From: Matthew Montgomery <Matthew.Montgomery@finance.nsw.gov.au>
Sent: Tuesday, 6 February 2018 5:00 PM
To: Tertius Greyling
Cc: SA Mail
Subject: RE: Mount Pleasant Coal Mine Mod 4 Exhibition Notice

I have reviewed our mapping records and the proposed rail spur location is within close proximity to abandoned workings of an unknown depth.

Figure 1: General Arrangement of the Mount Pleasant Operation and Key Modification Infrastructure

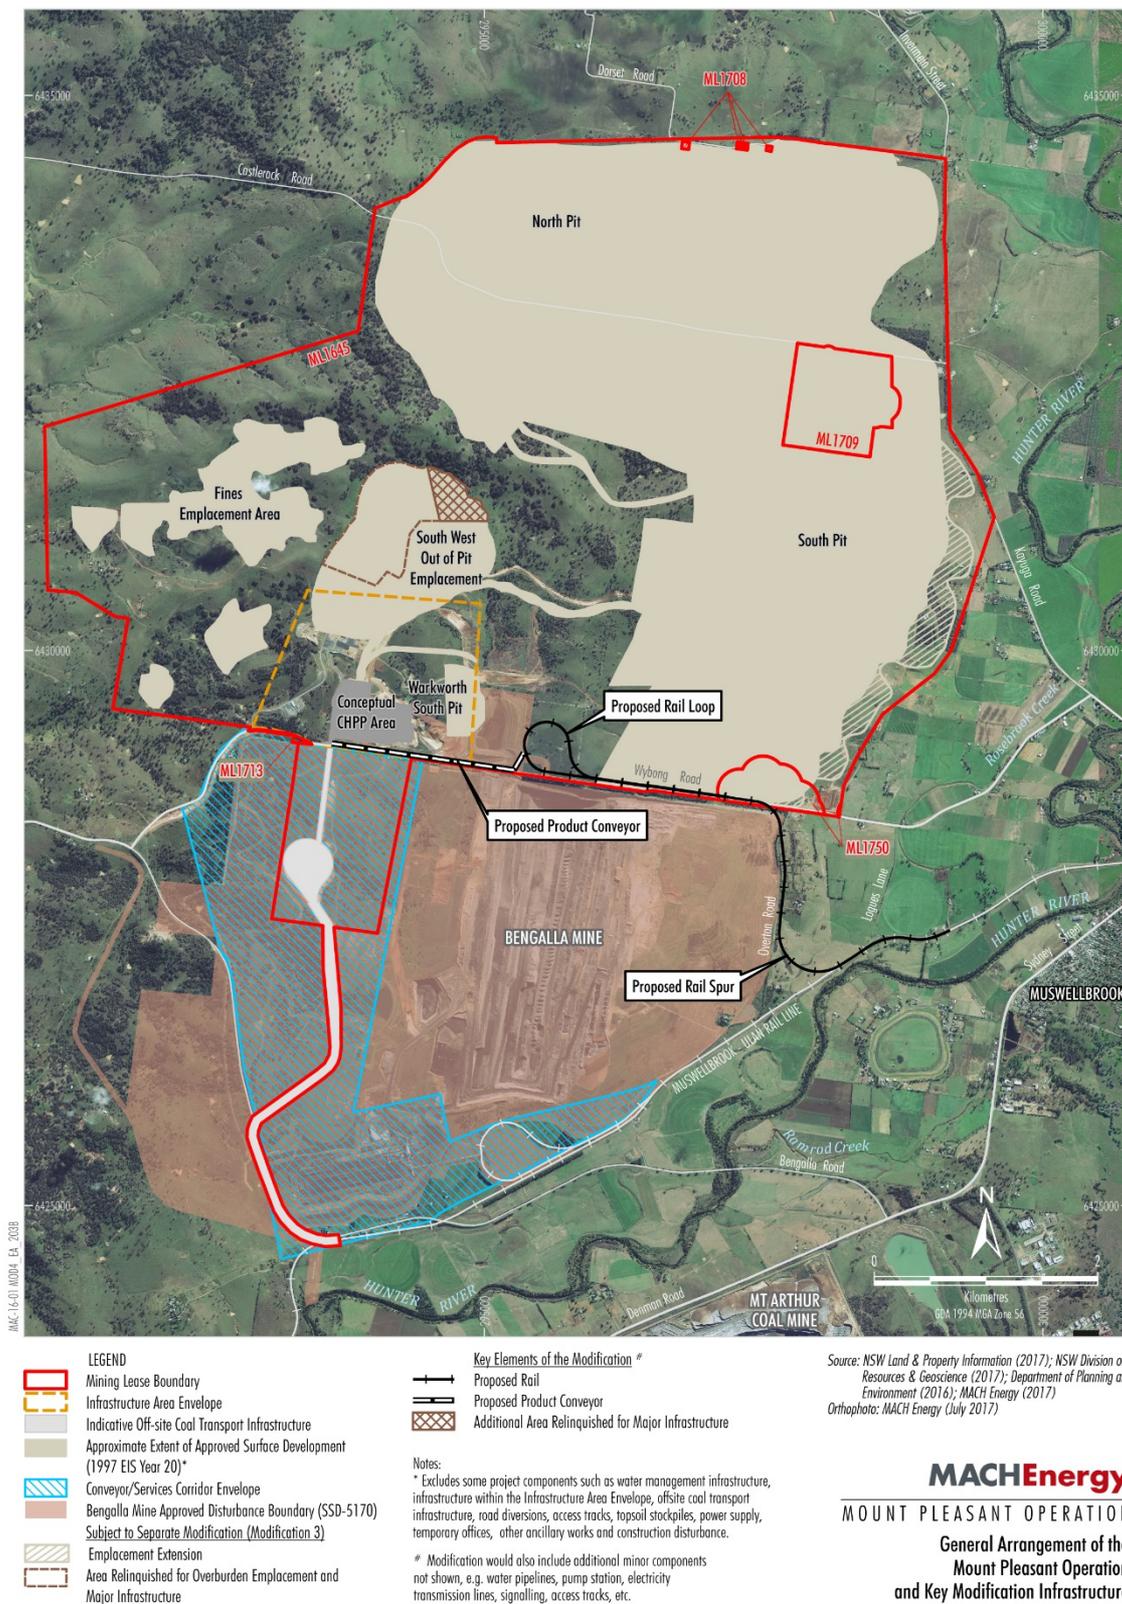
It is Subsidence Advisory NSW's (SA NSW) recommendation geotechnical investigations are carried out to determine the extent of the abandoned workings and ensure the spur is constructed outside the area of possible influence or eliminate the risk of subsidence occurring through means such as grouting.

As the proposed rail spur is located within a mine subsidence district, SA NSW approval is required prior to construction.
